**Our Ref:** VAR-1712

**RE: VARIATION OF CONDITIONS 2 (DESIGN), 10 (PARKING) AND 12 (INTERNAL LAYOUT) OF APPLICATION 20/00032/MNR TO INCLUDE DESIGN CHANGES; ALL WITH ASSOCIATED EXTERNAL WORKS AT 12 CLIVE ROAD, CANTON, CARDIFF, CF5 1HJ.**

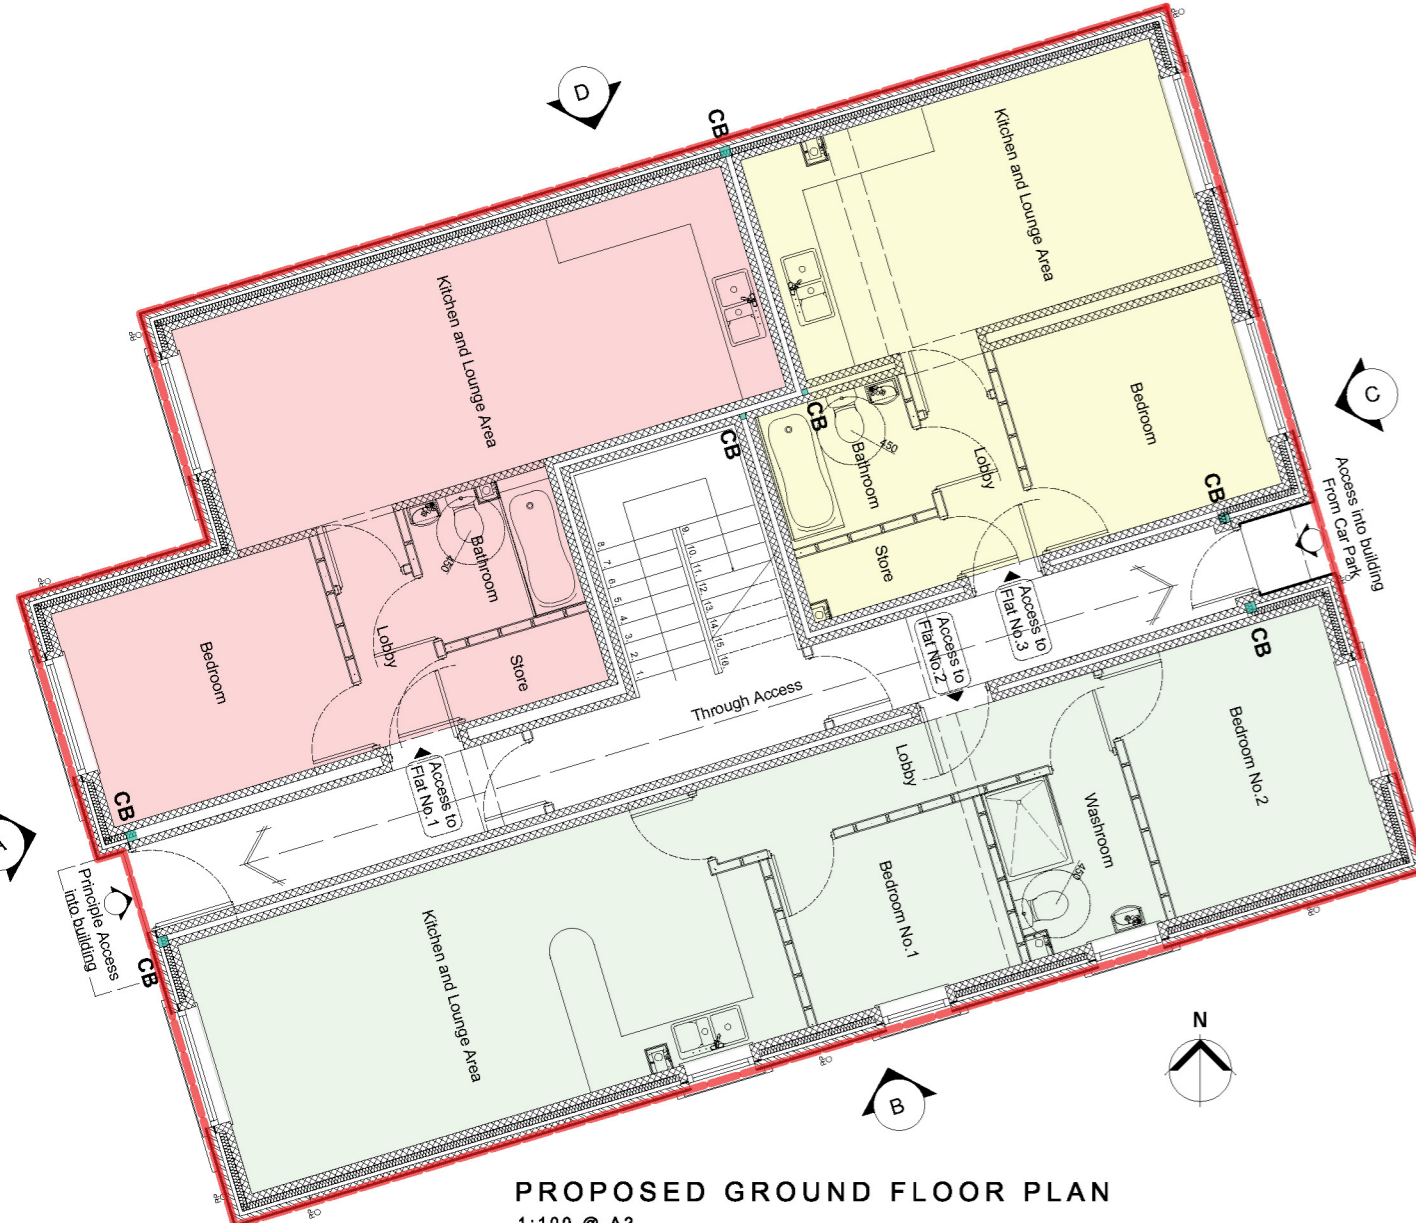
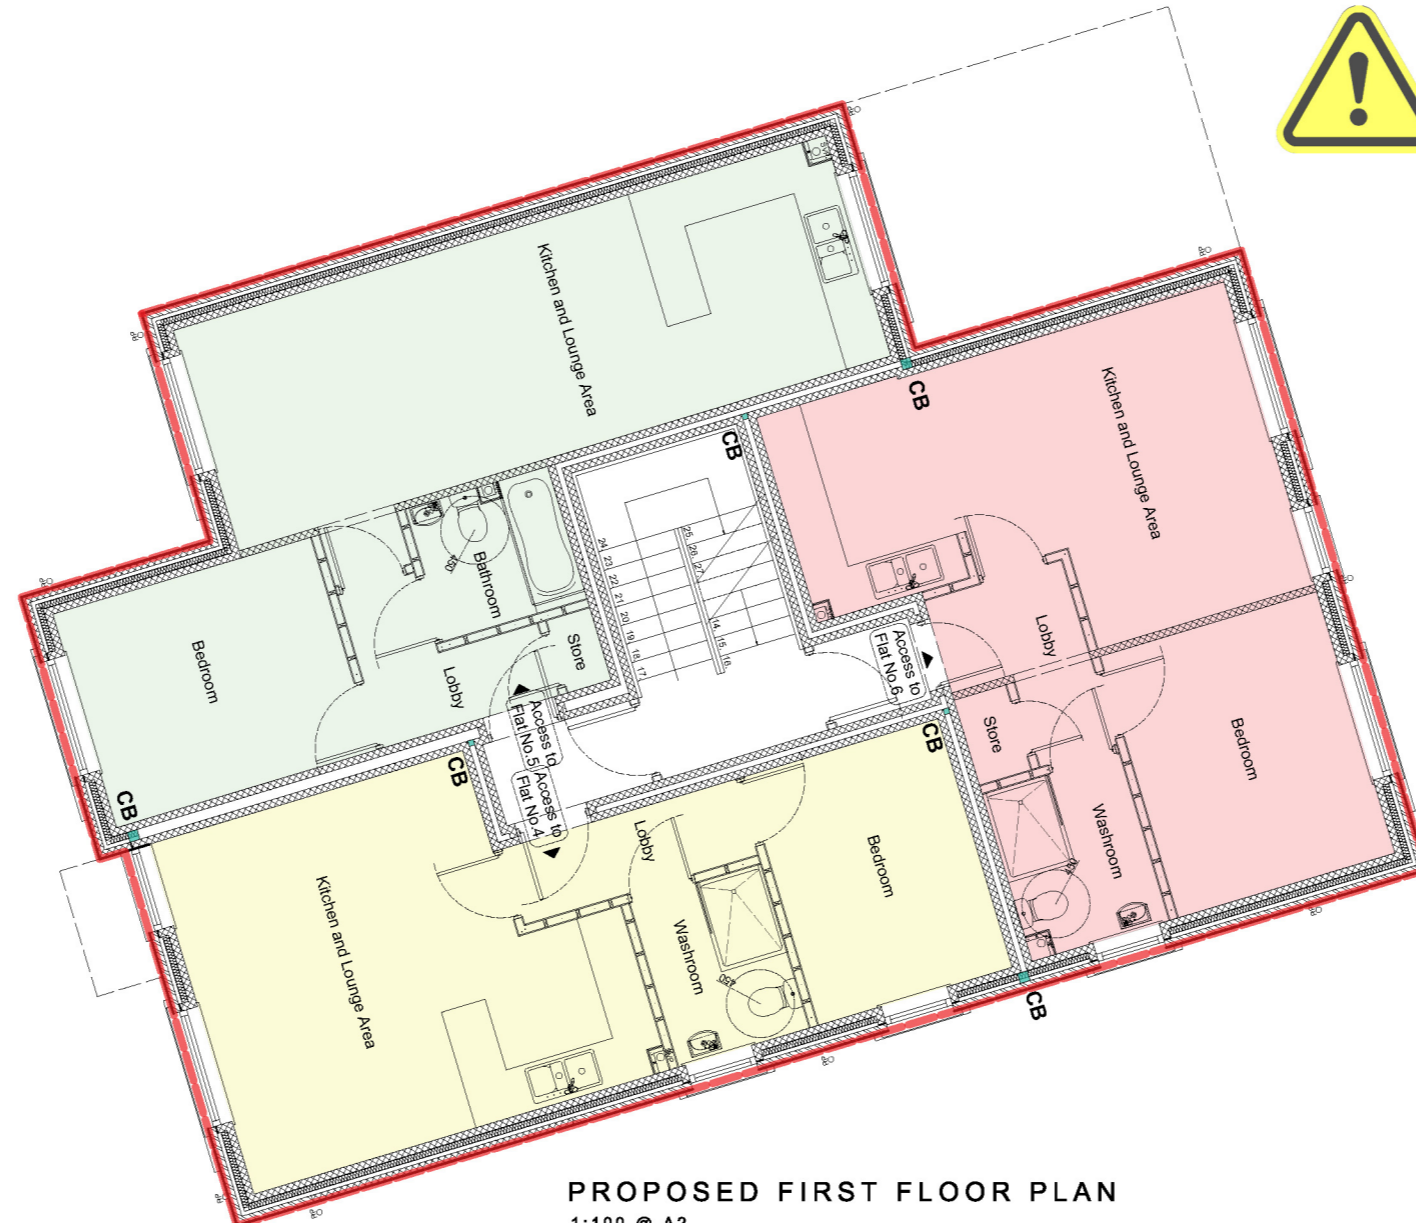
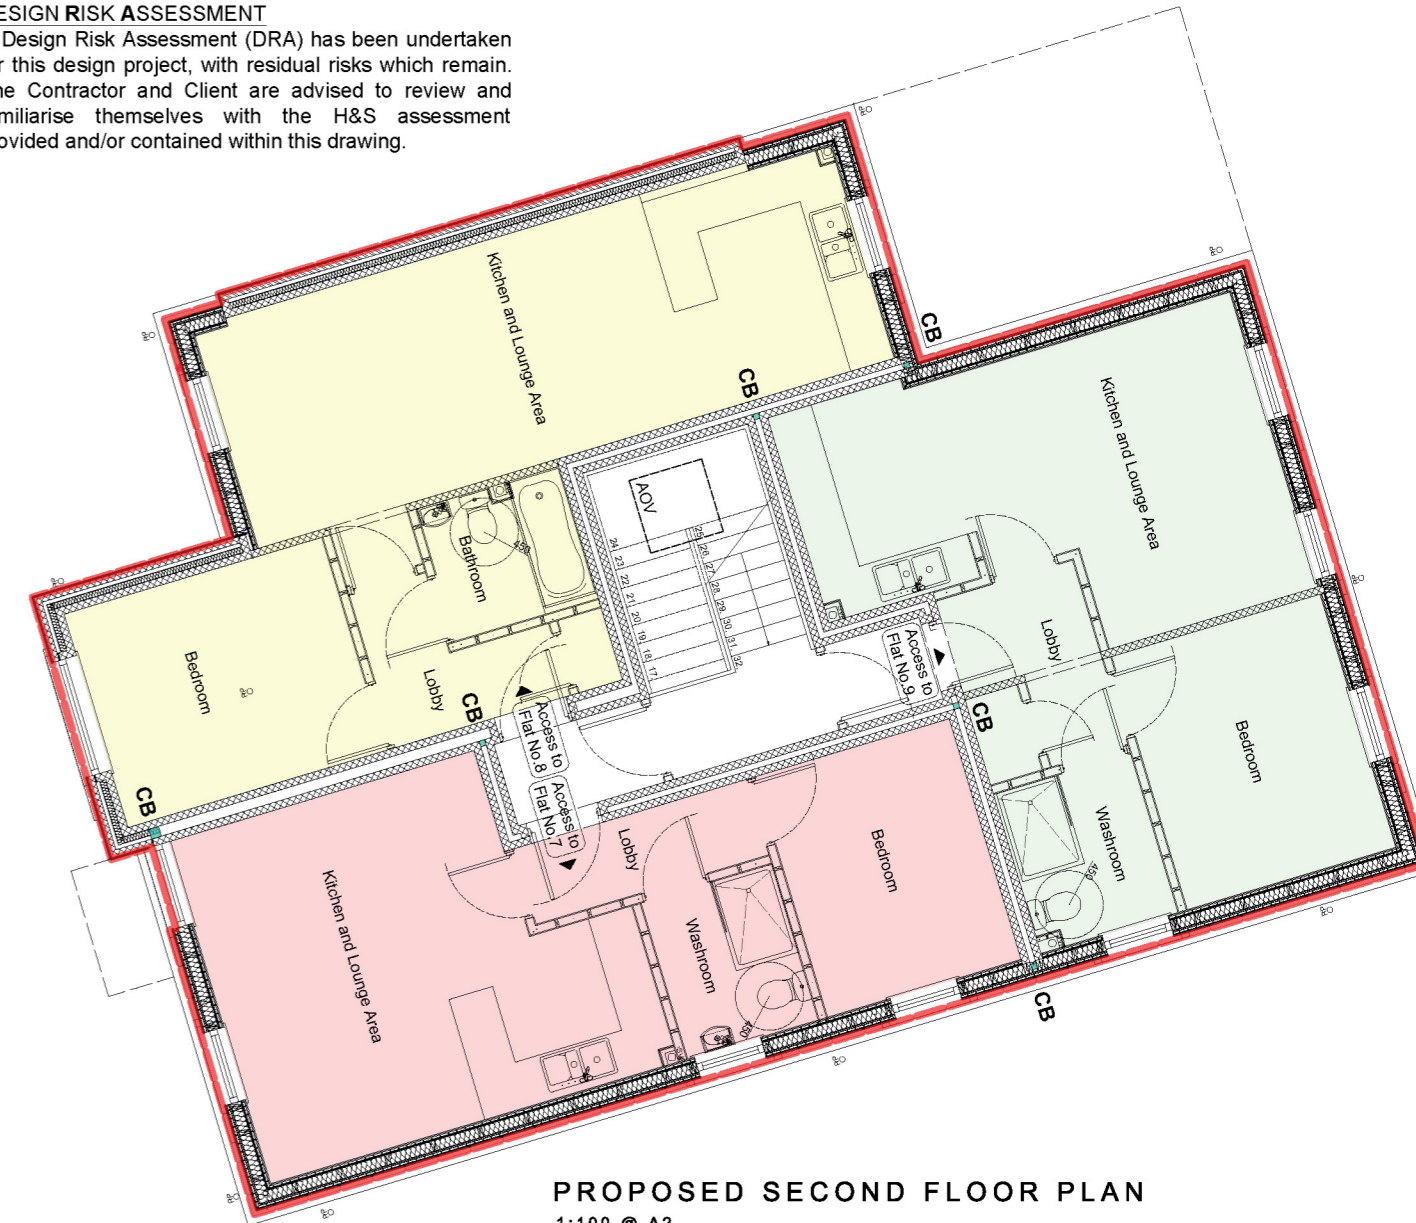
The external levels of the site and the internal floor level were found to be conflicting on technical grounds within the approved scheme such that the external ground was higher than the internal floor level. This obviously led to concerns with water ingress and has now been corrected.

We have also received feedback from a preliminary Building Regulation plan vet process which had identified issues with the approved layout in relation to Part B (of the Approved documents) Fire safety compliance, specifically the ground floor fire escape. This has also now been corrected in the submitted scheme.

The construction of the flat roof based upon the heights indicated on the approved scheme led to some reservations on technical grounds. The consequence of this was a marginal increase to the building height of approximately 100mm in order to satisfy technical design requirements.

As stated above the scheme has undergone a preliminary Building Regulation plan vet process, in which it was identified that through access would be required to comply with Part B of the Building Regulations (Fire Safety). Therefore we are looking to vary this condition to seek approval to the proposed changes to the layout. This is believed to offer a betterment to the approved layout as it provides through access.

To be superseded by Varco's drawing "D101- Proposed Floor Plans and elevations".

To be superseded by Varco's drawing "D101- Proposed Floor Plans and elevations".

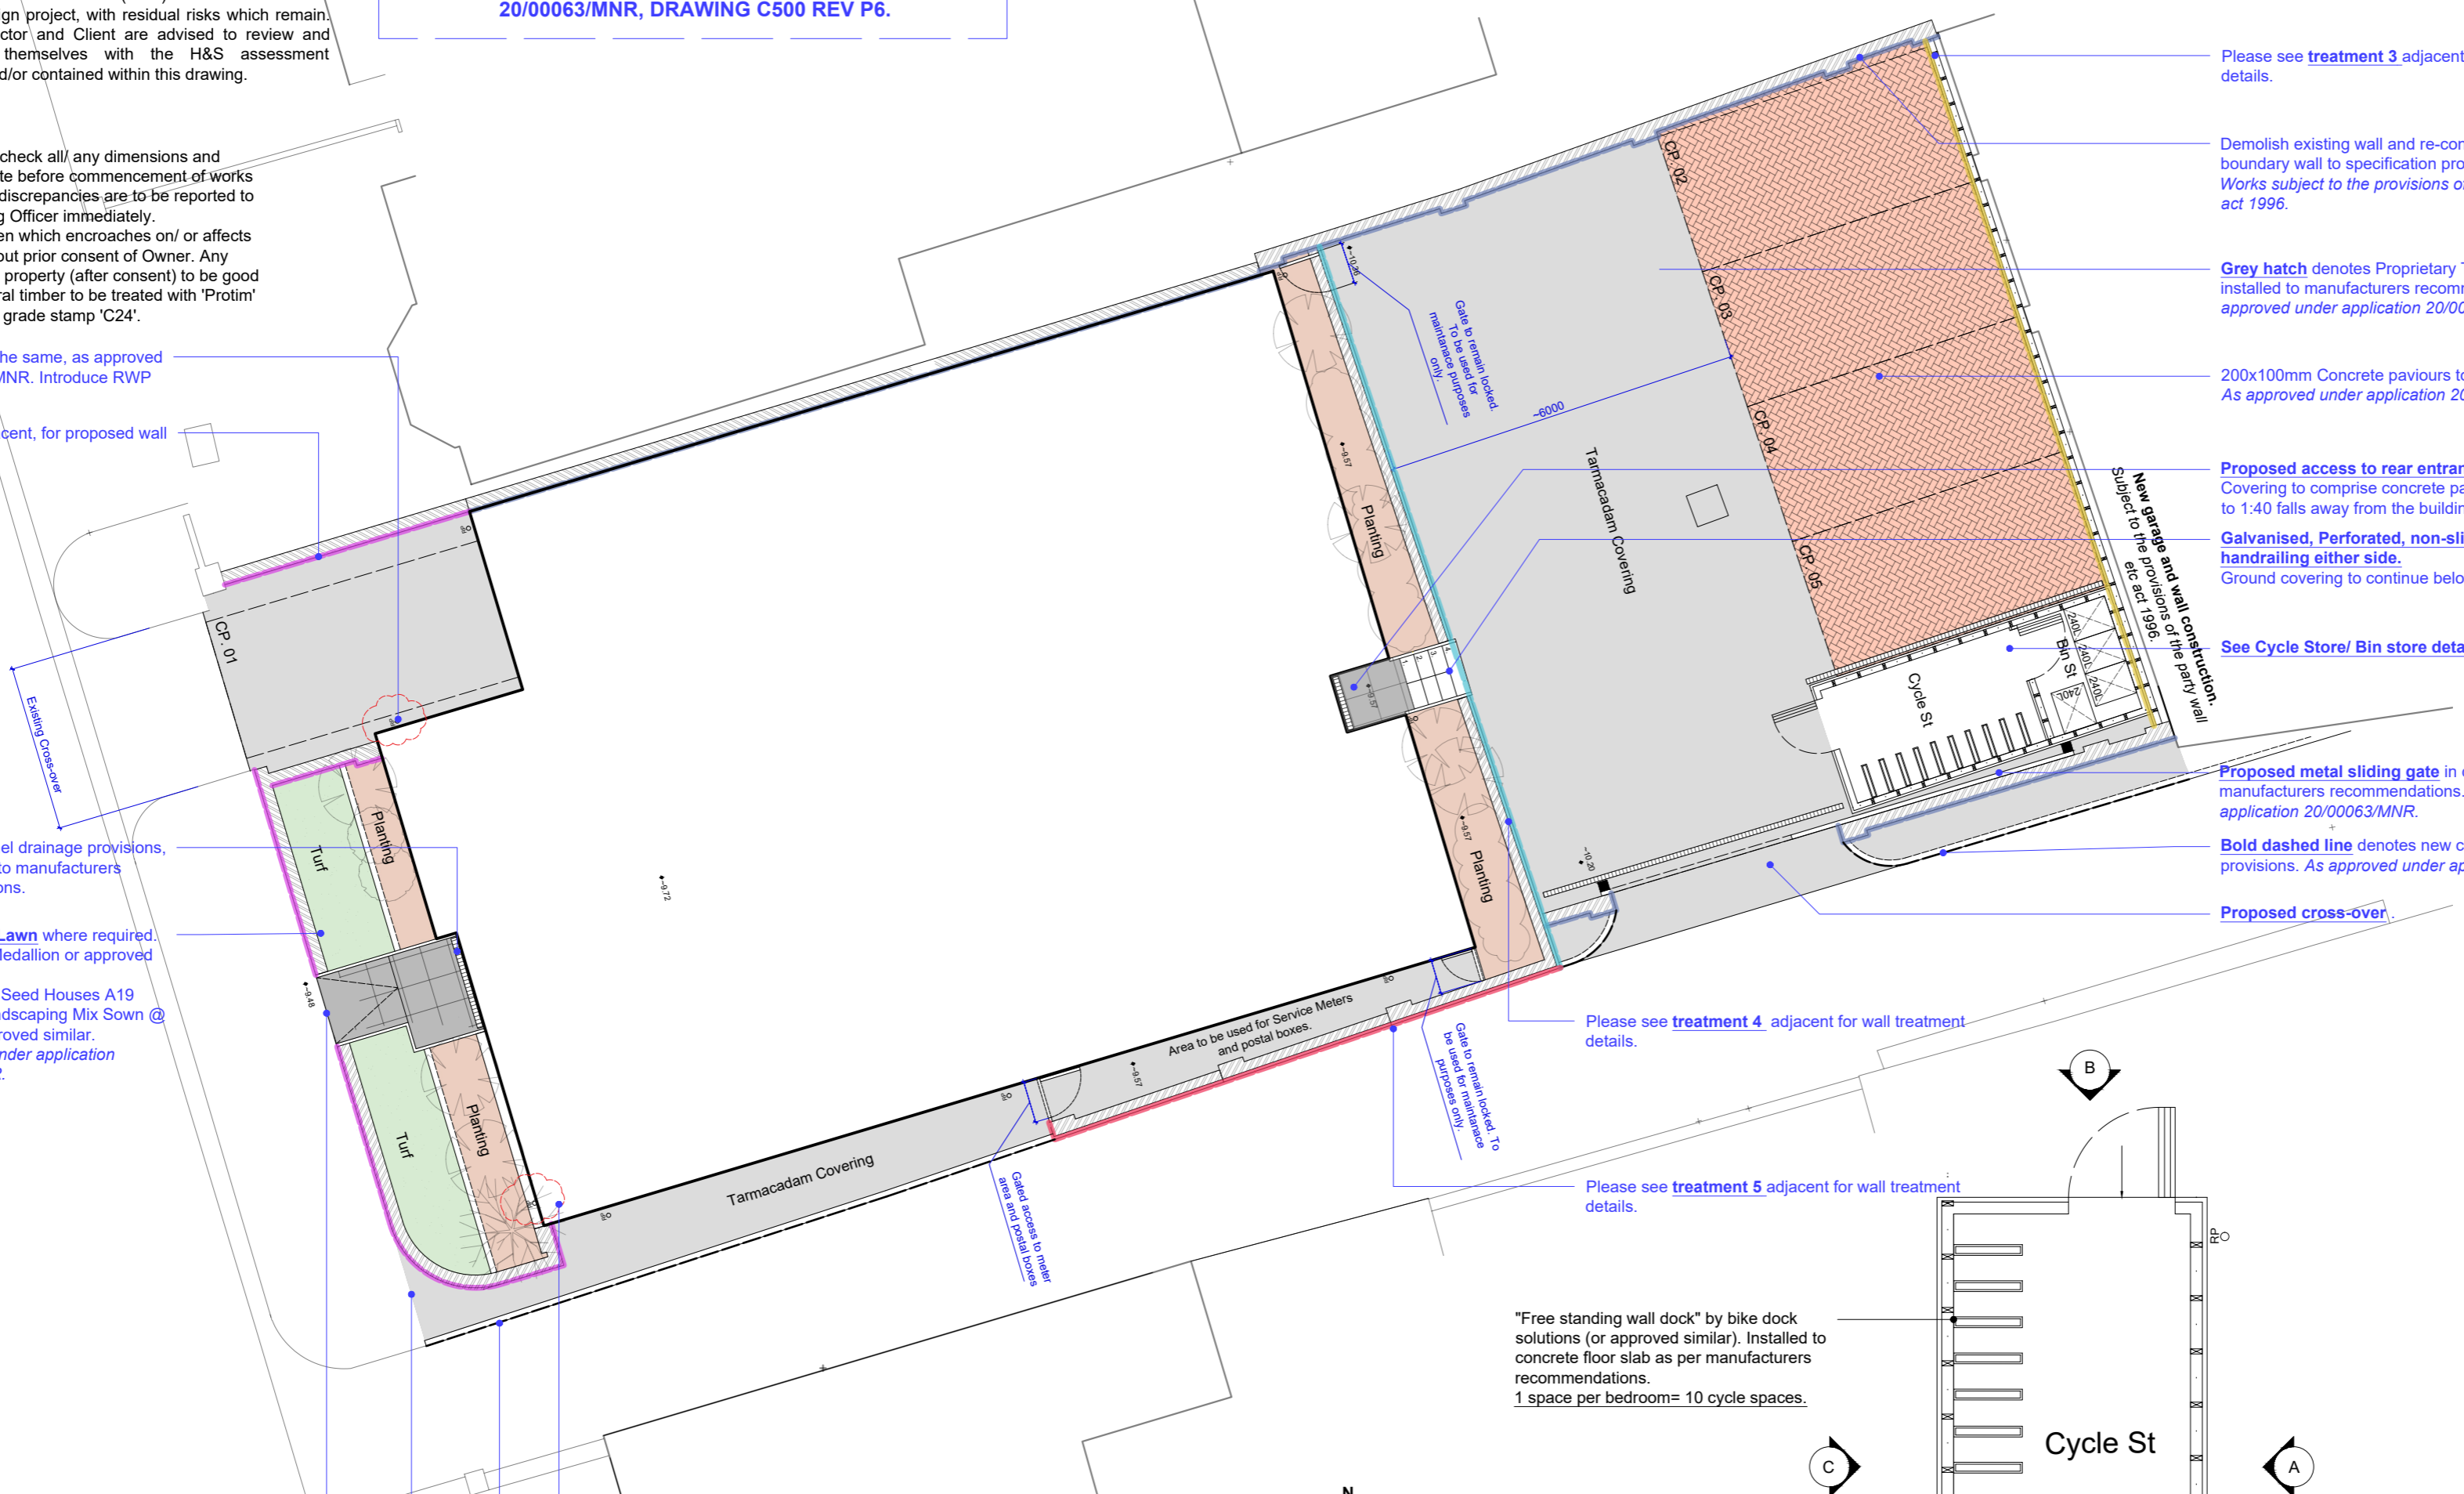
Alterations to the approved scheme to facilitate the above changes, alongside a review of the external works scheme with the latest site levels, and the production of our designer's risk assessment.

4. Introduction of a retaining boundary wall adjacent to No.14 Clive Road, in place of using the external wall of the development as a retaining/ boundary structure as indicated in the approved plans. Work is obviously subject to the provisions of the Party wall etc Act 1996.
5. Changes to the position and number of rainwater pipes (as specified in drawing D102), the scheme however does not look to increase the approved roof area.

6. Finally we have identified that in order to accommodate the number of cycle parking spaces and bin stores required, we have had to reduce the approved rear cross over width.

The parking design as approved in drawing AL (01)20: Proposed External works, has been re-implemented into Varco's superseded external works design in drawing "D102- Proposed external works and cycle store details".

To be superseded by Varco's drawing "D102- Proposed external works and cycle store details".
